**MOHAR FARM SHORT PLAT (SP-24-00005)
COMPLIANCE DOCUMENT**

MAY 9, 2024	FINDINGS OF FACT, DECISION & CONDITIONS OF APPROVAL - KITTITAS CO. COMMUNITY DEVELOPMENT SERVICES: ZACH TORRANCE-SMITH - PLANNER	1. BUILDING A. ALL NEW CONSTRUCTION MUST MEET THE INTERNATIONAL RESIDENTIAL CODE REQUIREMENTS. B. ENVIRONMENTAL AND STATUTORY REVIEW MAY BE REQUIRED FOR ALL CURRENT AND FUTURE DEVELOPMENT, CONSTRUCTION, AND IMPROVEMENTS. THE APPLICANT AND/OR ALL FUTURE OWNERS OF ANY LOT OR LOTS WITHIN THIS SUBDIVISION ARE RESPONSIBLE FOR COMPLIANCE WITH ALL APPLICABLE LOCAL, STATE, AND FEDERAL RULES, REQUIREMENTS, CODES, AND REGULATIONS. IT IS INCUMBENT UPON SAID APPLICANTS AND FUTURE OWNERS TO INVESTIGATE FOR, AND OBTAIN FROM THE APPROPRIATE AGENCY OR THEIR REPRESENTATIVE, ALL REQUIRED PERMITS, LICENSES, AND APPROVALS FOR ANY DEVELOPMENT, CONSTRUCTION, AND/OR IMPROVEMENTS THAT OCCUR WITHIN THE BOUNDARIES OF THIS SUBDIVISION.	Noted	
MAY 9, 2024	FINDINGS OF FACT, DECISION & CONDITIONS OF APPROVAL - KITTITAS CO. COMMUNITY DEVELOPMENT SERVICES: ZACH TORRANCE-SMITH - PLANNER	2. ROADS AND TRANSPORTATION A. THIS APPLICATION IS SUBJECT TO THE LATEST REVISION OF THE KITTITAS COUNTY ROAD STANDARDS. THE FOLLOW

SP-24-00005
SPF-24-00007

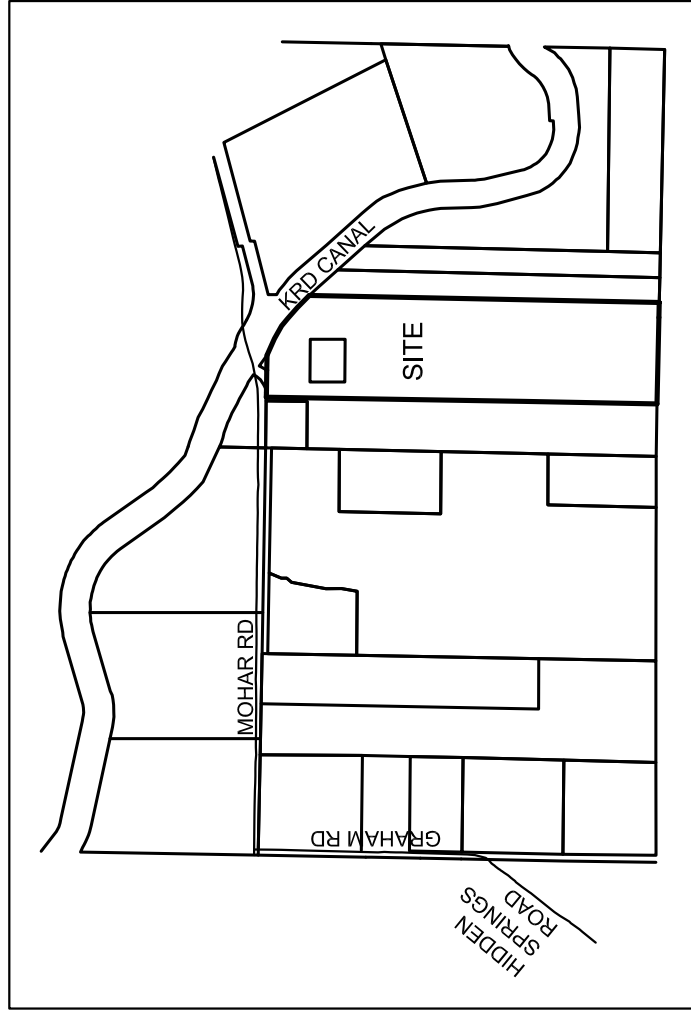
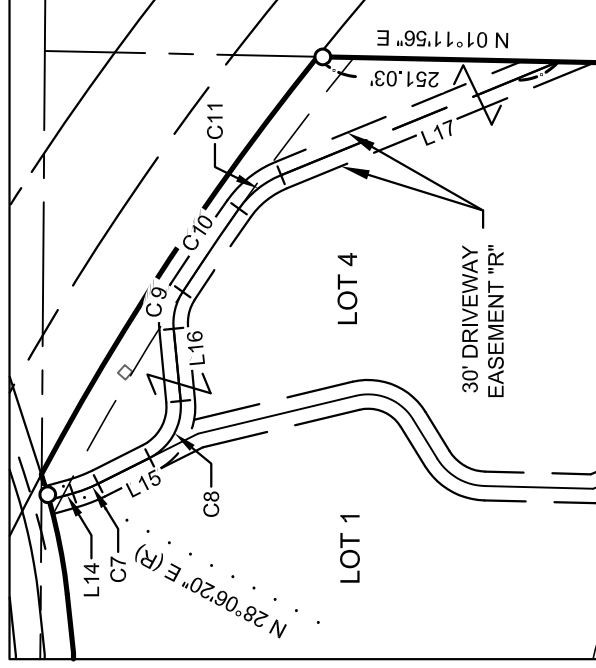
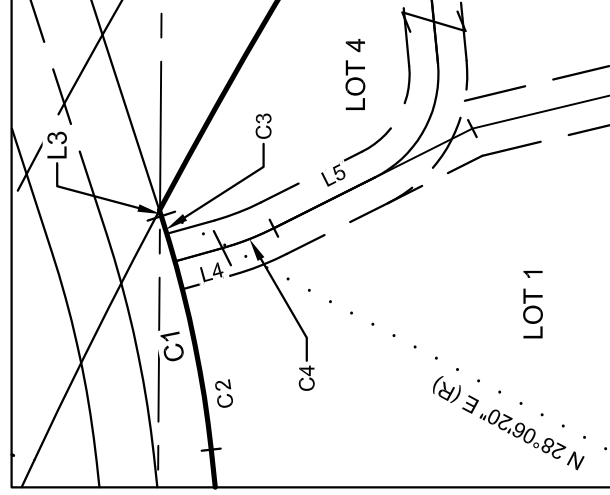
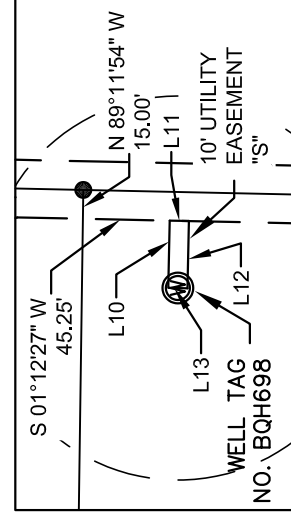
MAY 9, 2024	FINDINGS OF FACT, DECISION & CONDITIONS OF APPROVAL - KITTITAS CO. COMMUNITY DEVELOPMENT SERVICES: ZACH TORRANCE-SMITH - PLANNER	3. STATE AND FEDERAL A. APPLICANT SHALL MEET ALL STATE AND FEDERAL REGULATIONS.	Noted	
MAY 9, 2024	FINDINGS OF FACT, DECISION & CONDITIONS OF APPROVAL - KITTITAS CO. COMMUNITY DEVELOPMENT SERVICES: ZACH TORRANCE-SMITH - PLANNER	4. SURVEY A. THE NEW DIVISION LINE SHALL HAVE CORNERS SET IN THE FIELD AND BE SHOWN ON THE FACE OF THE SURVEY.	WILL COMPLY

B. THE FINAL PLAT SHALL SHOW THE BASIS OF BEARING.	BASIS OF BEARING SHOWN	
MAY 9, 2024	FINDINGS OF FACT, DECISION & CONDITIONS OF APPROVAL - KITTITAS CO. COMMUNITY DEVELOPMENT SERVICES: ZACH TORRANCE-SMITH - PLANNER	5. PLAT NOTES A. THE FOLLOWING PLAT NOTES SHALL BE RECORDED ON THE FINAL MYLAR DRAWINGS: * ENVIRONMENTAL AND STATUTORY REVIEW MAY BE REQUIRED FOR ALL CURRENT AND FUTURE DEVELOPMENT, CONSTRUCTION, AND IMPROVEMENTS. THE APPLICANT AND/OR ALL FUTURE OWNERS OF ANY LOT OR LOTS WITHIN THIS SUBDIVISION ARE RESPONSIBLE FOR COMPLIANCE WITH ALL APPLICABLE LOCAL, STATE, AND FEDERAL RULES, REQUIREMENTS, CODES, AND REGULATIONS. IT IS INCUMBENT UPON SAID APPLICANTS AND FUTURE OWNERS TO INVESTIGATE FOR, AND OBTAIN FROM THE APPROPRIATE AGENCY OR THEIR REPRESENTATIVE, ALL REQUIRED PERMITS, LICENSES, AND APPROVALS FOR ANY DEVELOPMENT, CONSTRUCTION, AND/OR IMPROVEMENTS THAT OCCUR WITHIN THE BOUNDARIES OF THIS SUBDIVISION. * ALL DEVELOPMENT SHALL COMPLY WITH INTERNATIONAL FIRE CODE. * MAINTENANCE OF THE ACCESS IS THE RESPONSIBILITY OF THE PROPERTY OWNERS WHO BENEFIT FROM ITS USE.	ALL PLAT NOTES HAVE BEEN ADDED TO THE SHORT PLAT.

D. BOTH SHEETS OF THE FINAL MYLARS SHALL REFLECT SHORT PLAT NUMBER SP-24-00005 AND AN ACCURATE LEGAL DESCRIPTION SHALL BE SHOWN ON THE FACE OF THE FINAL PLAT. ENGINEERS AND SURVEYORS NEED TO BE COGNIZANT OF ALL THE REQUIREMENTS RELATED TO FINAL PLATS (KCC 16.20) AND SURVEY DATA AND DEDICATIONS (KCC 16.24). THE FINAL PLAT MUST BE SUBMITTED IN FULL CONFORMANCE WITH THESE CHAPTERS OF KITTITAS COUNTY CODE; NON-COMPLIANT MYLARS WILL BE REJECTED AND RETURNED TO THE APPLICANT. A FINAL PLAT FILE NUMBER WILL BE ASSIGNED WHEN CDS RECEIVES YOUR FINAL PLAT APPLICATION. THIS FILE NUMBER WILL ALSO BE REQUIRED ON THE FACE OF THE FINAL PLAT.	SHORT PLAT NUMBER IS ADDED. ALL OTHER COMMENTS ARE NOTED AND APPLICANT HAS COMPLIED.
